Condition 3.

Hennock International Ltd

Pipe to be laid on 100mm sand or screened excavated material as per normal practice, then covered with similar to minimum 100mm depth, then backfilled spoil.
Width to suit pipe diameter and bucket.

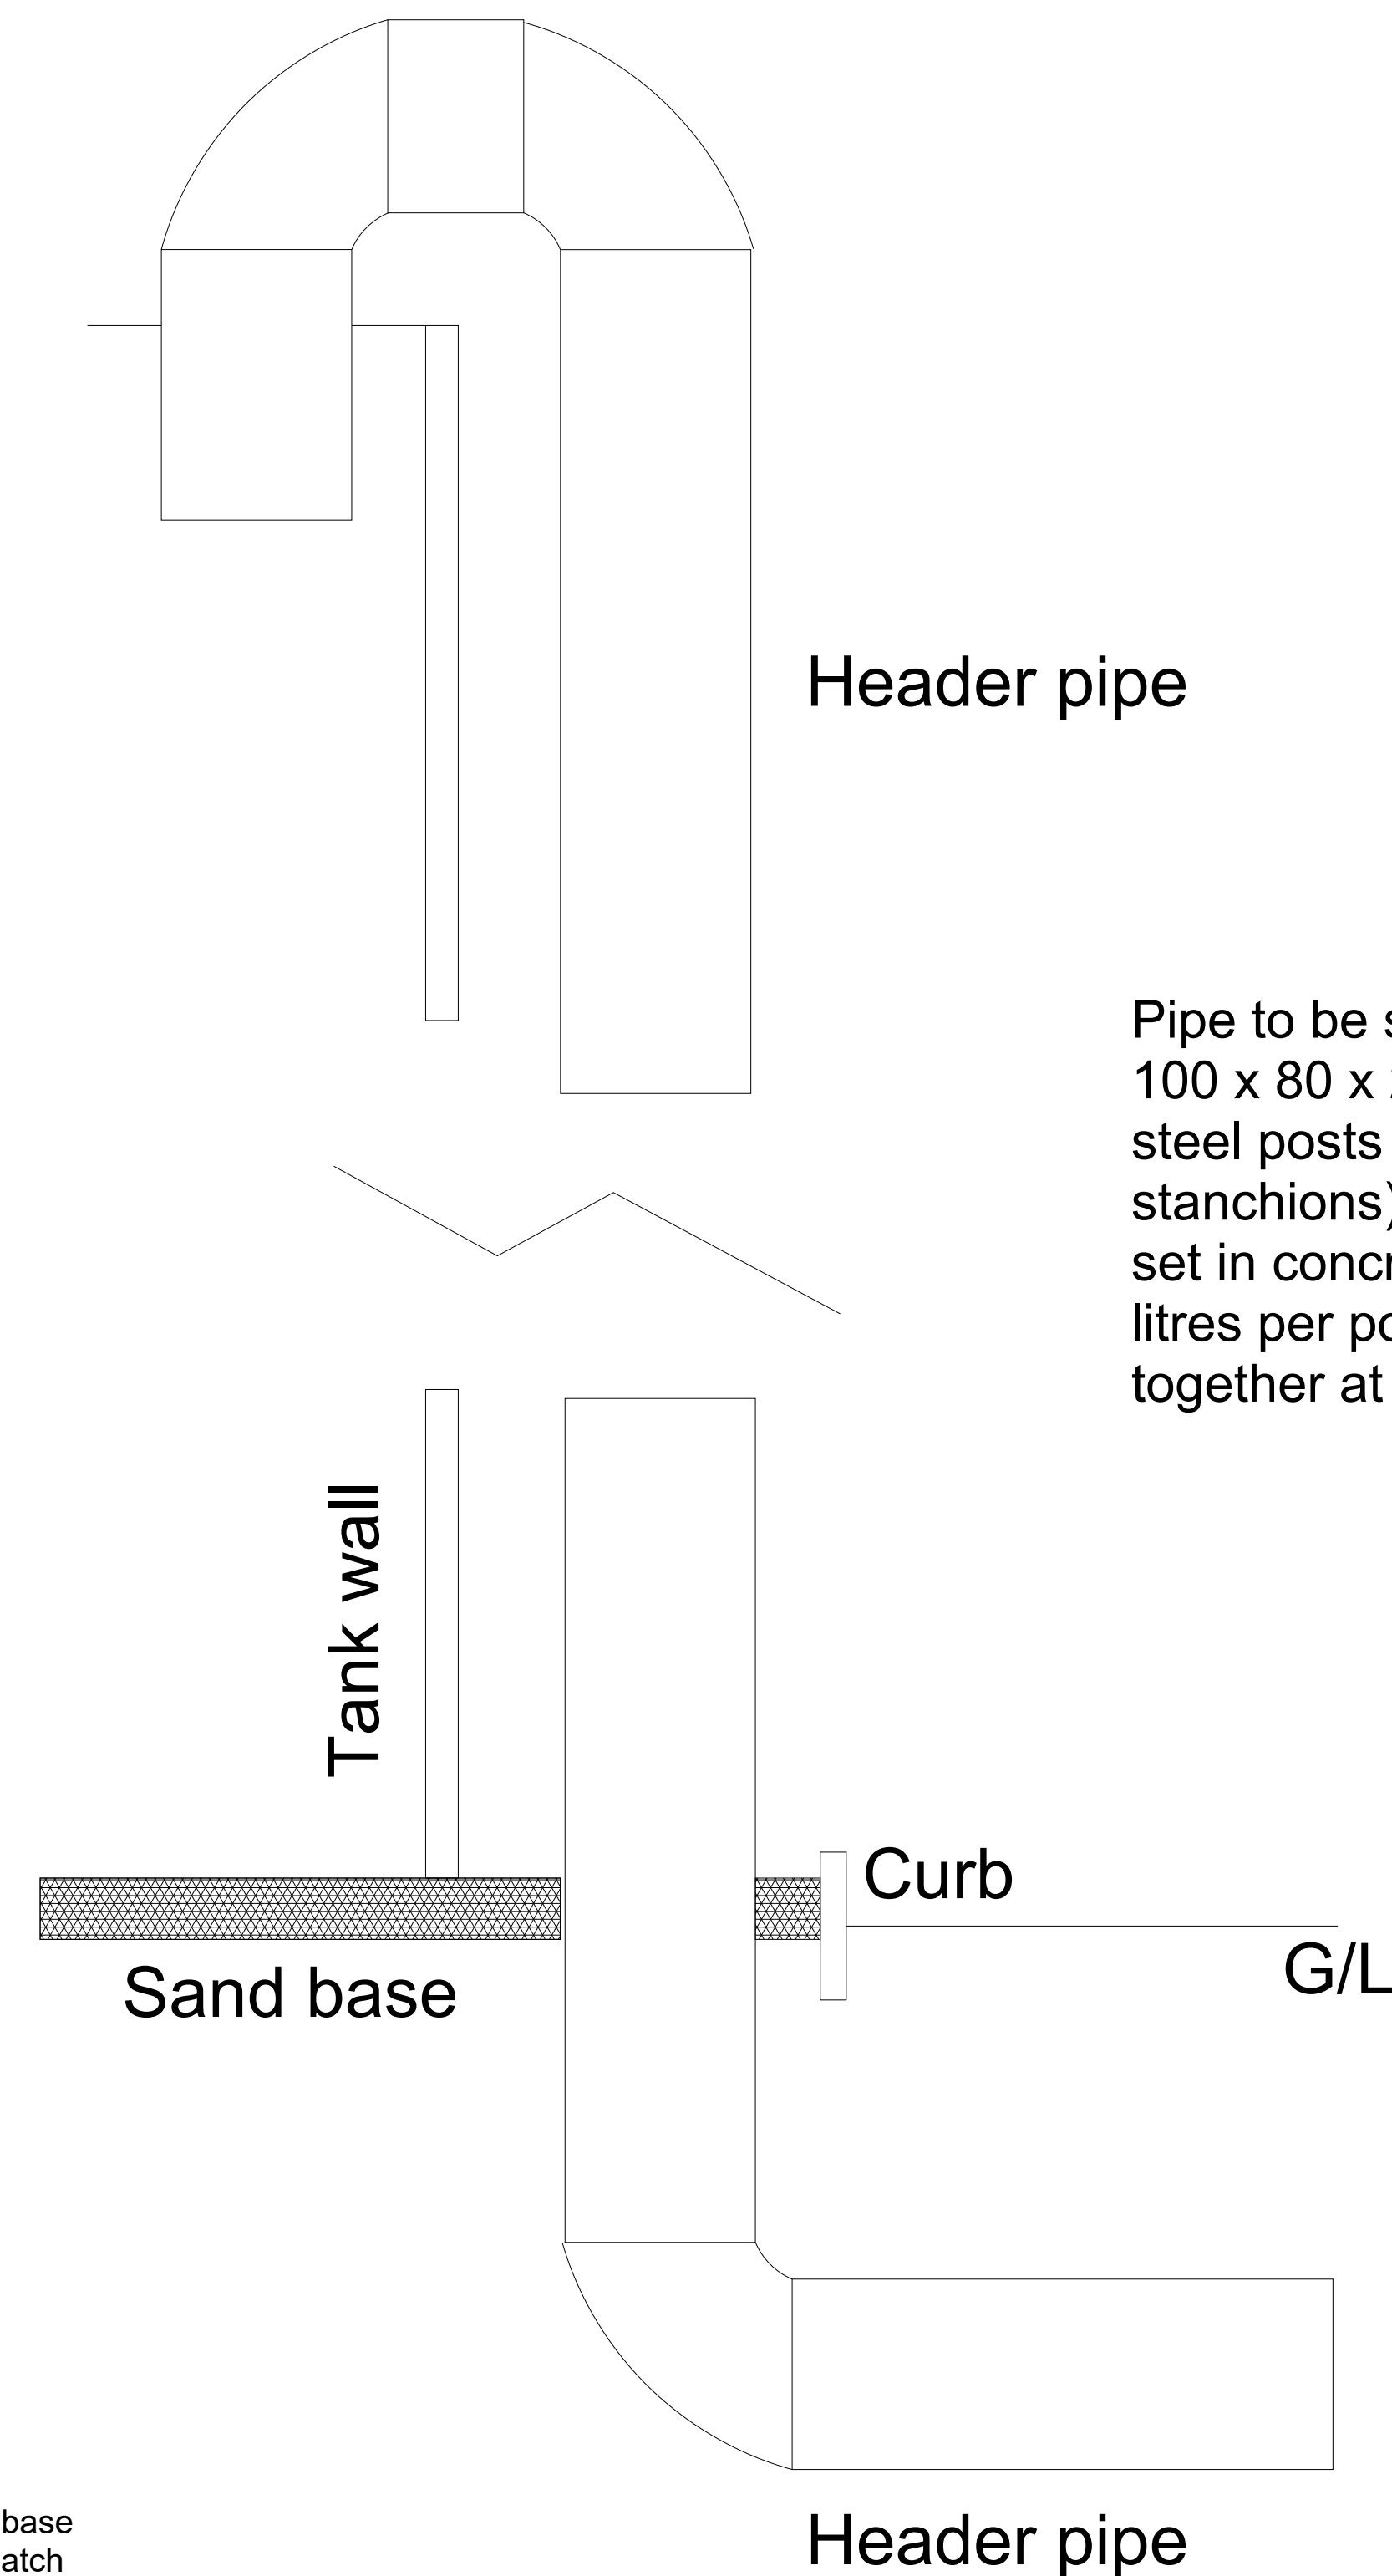
See also "Drain installation details" drawing.
